CITY OF ALBUQUERQUE

June 5, 2017

**Re: Violations at 9000 Alameda Blvd NE Albuquerque
Hydrology file C20D073**

8/28/15 *** RND. 2 THE JONES HOME
1/2/15 Add T. F. Grading, Site, and Drainage Plan

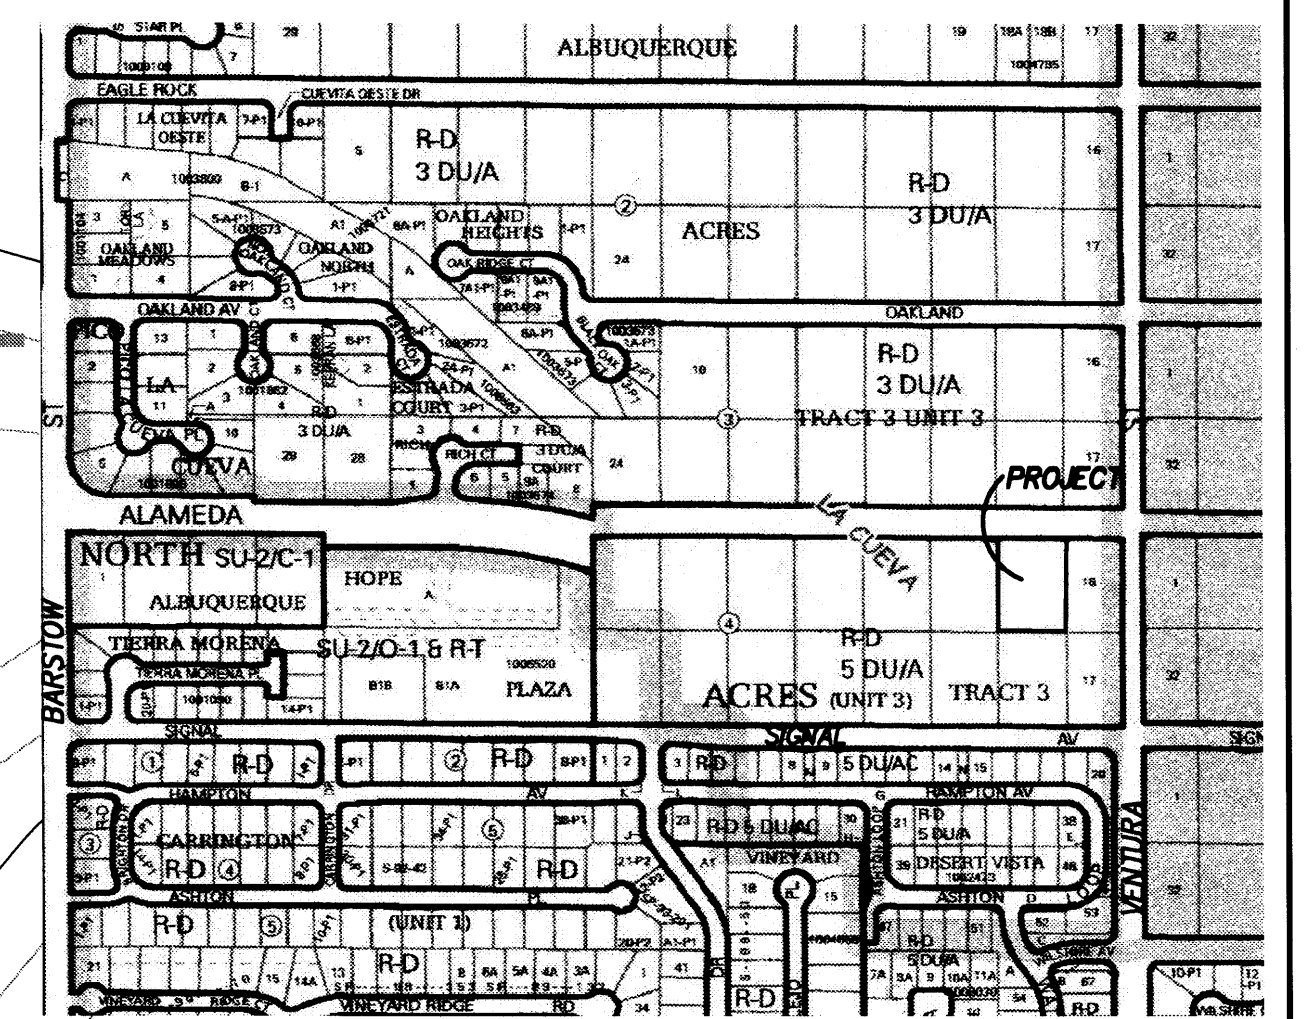
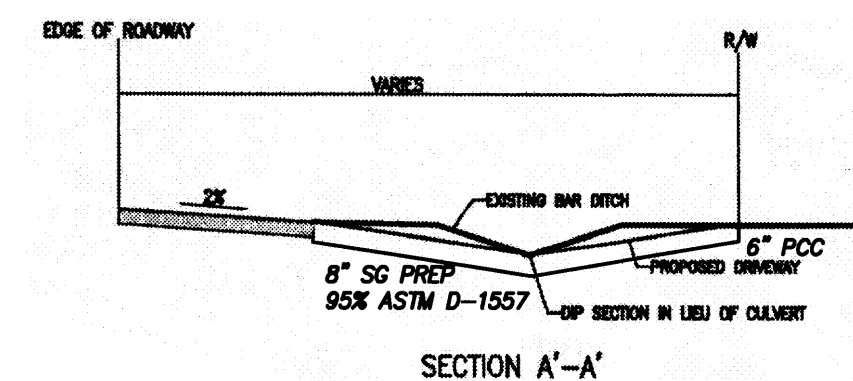
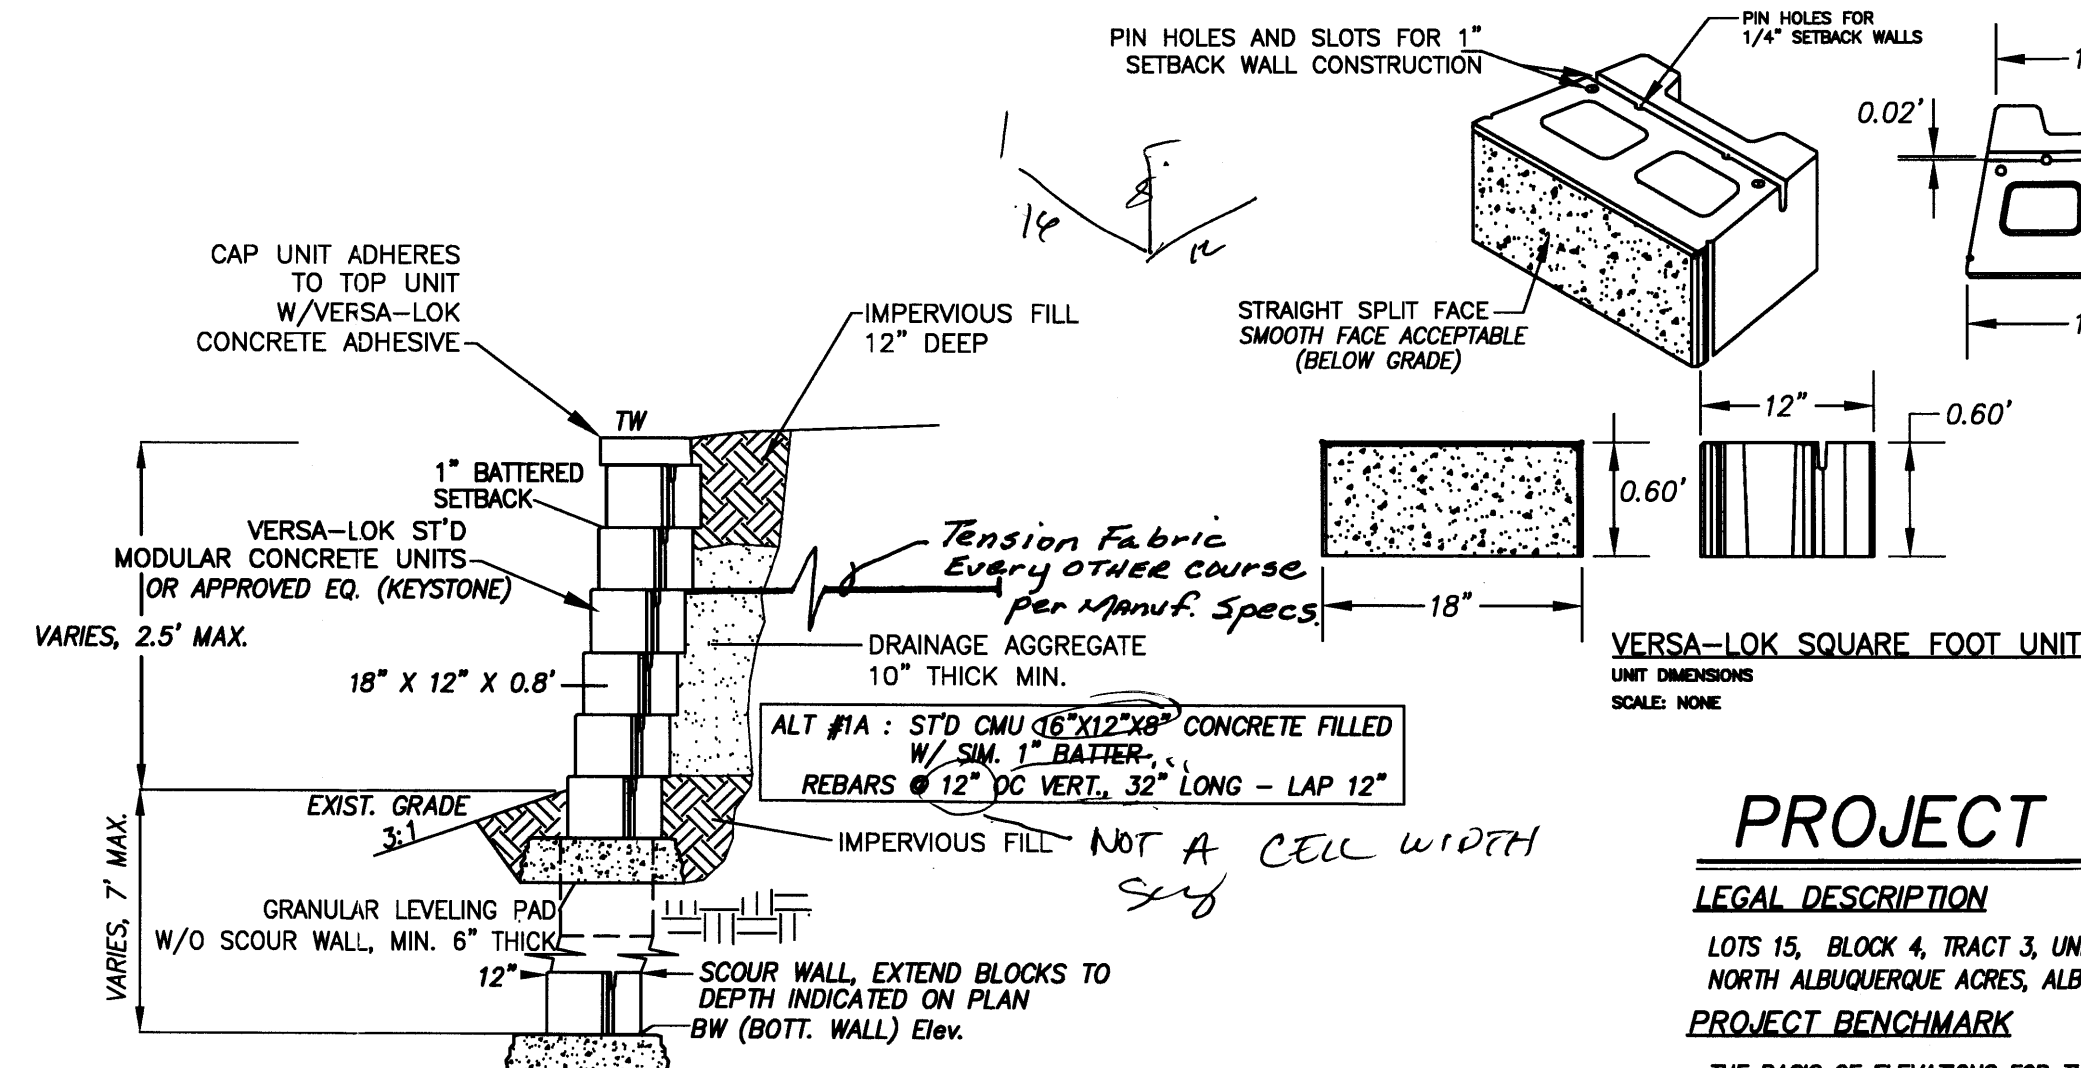
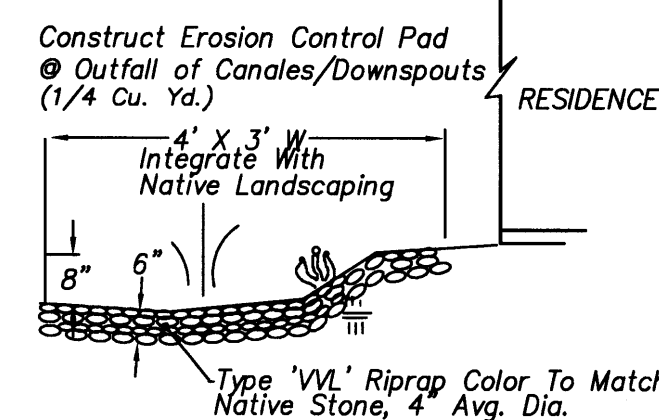
The purpose of this letter is to inform you that the obstructions you have placed in the South La Cueva Arroyo at 9000 Alameda Blvd increase the flood risk to the properties on the south side of the arroyo and increase the erosion risk to the downstream properties. The act of placing these obstructions without the appropriate permits from the City of Albuquerque and the US Army Corps of Engineers is in violation of City, State and Federal laws. Upon Conviction, the City of Albuquerque Code of Ordinances 1-1-99 sets a fine not to exceed \$500 or imprisonment not to exceed 90 days for each Violation, with each day that the violation persists constituting a separate violation. If a court finds a violation of the United States Clean Water Act, CWA, due to criminal negligence (e.g., carelessness, inattentiveness), it will impose a fine (a minimum of \$2,500 with a maximum of \$25,000 fine per day for the first offence). This violation was noted in an e-mail sent to you by the City Engineer on May 17, 2016 and as of the date of this letter it has still not been corrected. As the floodplain administrator for the city of Albuquerque I implore you to take corrective action and remove these obstructions before they cause significant harm to the neighbor's property. This letter will serve as notice that if the violation is not corrected by July 1, 2017 you will be subject to **IMMEDIATE** court action.

Fill has been placed in the thalweg of the arroyo on your property which raises the Base Flood Elevation, BFE, both on your property and on the neighbor's property south of the arroyo. Also fill has been placed in a berm along the upstream edge of your property further increasing the risk of flooding on your neighbor's property south of the arroyo. According to the grading plan that was approved by the city of Albuquerque with the engineer's stamp dated 9-2-2015, fill was only permitted outside of the floodplain on the north side of the arroyo, and the permit did not show any grading in the floodplain. All fill and other obstructions in the Special Flood Hazard Area, SFHA, occurred without a permit and must be removed.

The wrought iron fence that has been placed across the arroyo at the upstream and downstream sides of the property also increases the risk of flooding to your neighbor's property on the south side of the arroyo and must be removed. The fence was placed in the SFHA without a permit in violation of Code 14-5-1-15-(A) which requires a permit prior to changes in land use. The fence will block debris that is naturally transported by storm water runoff down the arroyo. Debris that gets caught on the fence will block storm water runoff and raise the BFE on the upstream side of the fence thus producing an increased risk of flood damage to the neighboring property on the south side of the arroyo.

Sediment transport is a natural function of the arroyo that has been disrupted by the landscape materials (rock, sod, etc.) that have been placed in the bed and banks of the arroyo on the property at 9000 Alameda Blvd. again constituting a violation of Code 14-5-1-15-(A) which requires a permit prior to changes in land use. The natural sand bed of the arroyo that previously ran through 9000 Alameda functioned as a source of sediment to feed the downstream natural sand bed arroyo. The landscape materials will cause incoming sediment to drop out of the storm water runoff as it passes through your property so sediment starved runoff will be delivered from your property to downstream resulting in excessive erosion on the downstream properties.

The safety of your neighbors' property depends on the swift removal of the obstruction (the fill, the fence, and the landscape material) that you placed in the SFHA. Prior to removal you will need a Grading Permit, a Floodplain Permit, and an ESC Permit with approved plans for each. Failure to comply will result in the filing of a criminal complaint against you. **This is the final notice you will receive prior to court action.**

If the obstructions in the Special Flood Hazard Area (SFHA) are not promptly removed by you then the City Engineer will cause the removal of all obstructions and the reasonable cost of removal shall constitute a lien against the lot at 9000 Alameda Blvd. in accordance with Code 14-5-1-15(D)(2). The lien shall be imposed and foreclosed in the manner provided in Sections 3-36-1 NMSA 1978.
